**WELWYN HATFIELD BOROUGH COUNCIL
EXECUTIVE DIRECTOR - PLANNING, PUBLIC PROTECTION AND GOVERNANCE**

Application No: 6/2021/1771/EM
Location: 22 Rooks Hill Welwyn Garden City AL8 6ET
Proposal: Garage conversion and erection of first floor extension.
Officer: Mr James Homer

Recommendation: Refused

Rev.	Revision	Date
1/0		
Rear Extension to First floor & Garage Conversion to Play and Office space.		
Proposed Elevations		
22 Ecks Hill, WGC	Mr & Mrs Moor	
March 2021	1:100 @A5	FP.08.05.21
 asg developments - herbs: 14 Old Rectory (the) Hatfield, Herts, AL10 8PF T: 01707 261927 M: 07894 761012

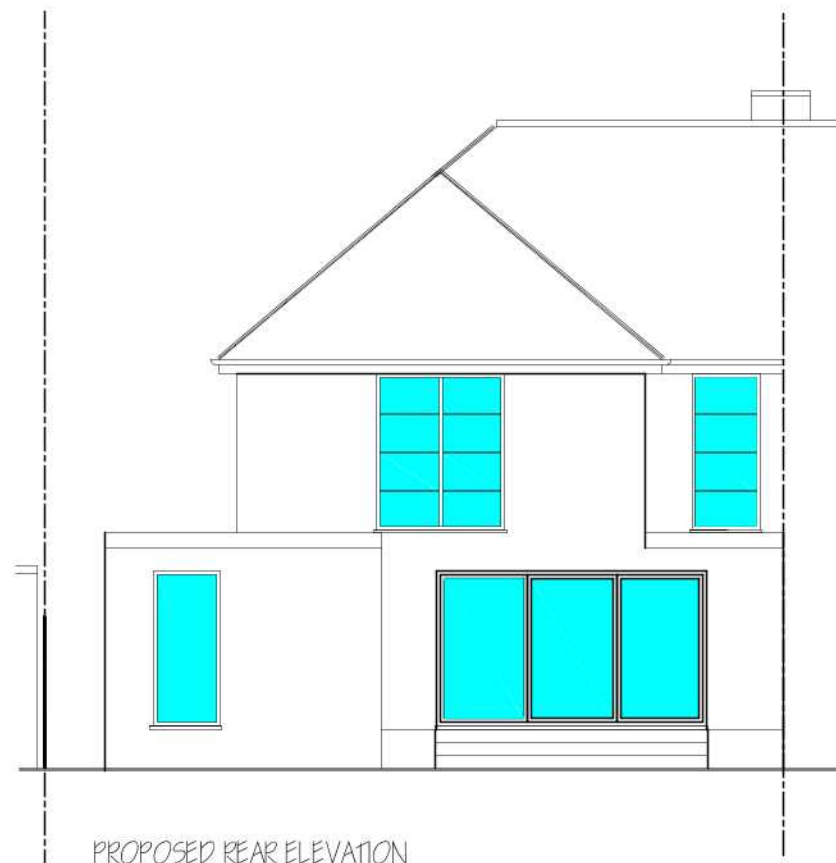
considered harmful to the character of the home and street scene.
Impact on neighbours	The proposed single storey rear/side extension would include a window and door within the flank elevation, however, these would look to the side wall of the neighbouring garage at no.20. A small window, to serve an en-suite bathroom, is also proposed for the side elevation of the first floor extension which faces toward no.22. No detail is given for this window therefore a condition to ensure obscure glazing and non-opening below 1.7m can be included if necessary. All other windows face the rear garden and would offer views similar to those from existing windows. The therefore, proposed extensions are unlikely to result in a harmful loss of light, outlook or privacy to neighbouring homes.
Landscaping issues (incl. hardstandings)	None.
Any other considerations	None.
Conclusion	
Although the proposed extensions would remain proportionate and subordinate to the original home and would reflect the constraints of the existing built form, the garage is considered to be a characteristic feature of the street scene and will result in a break in the symmetry currently seen within the semis of Rooks Hill. The loss of the garage to allow the erection of the side/rear extension and subsequent impact upon the property and wider street scene is considered harmful to the character of the home and street scene. As a result, the application fails to comply with Policy EM1 of the Estate Management Scheme.

1. Although the proposed extensions would remain proportionate and subordinate to the original home and would reflect the constraints of the existing built form with regard to depth into the garden, the garage is considered to be a characteristic feature of the street scene and will result in a break in the symmetry currently seen within the semis of Rooks Hill. The loss of the garage to allow the erection of the side/rear extension and subsequent impact upon the property and wider street scene is considered harmful to the character of the home and street scene. As a result, the application fails to comply with Policy EM1 of the Estate Management Scheme.
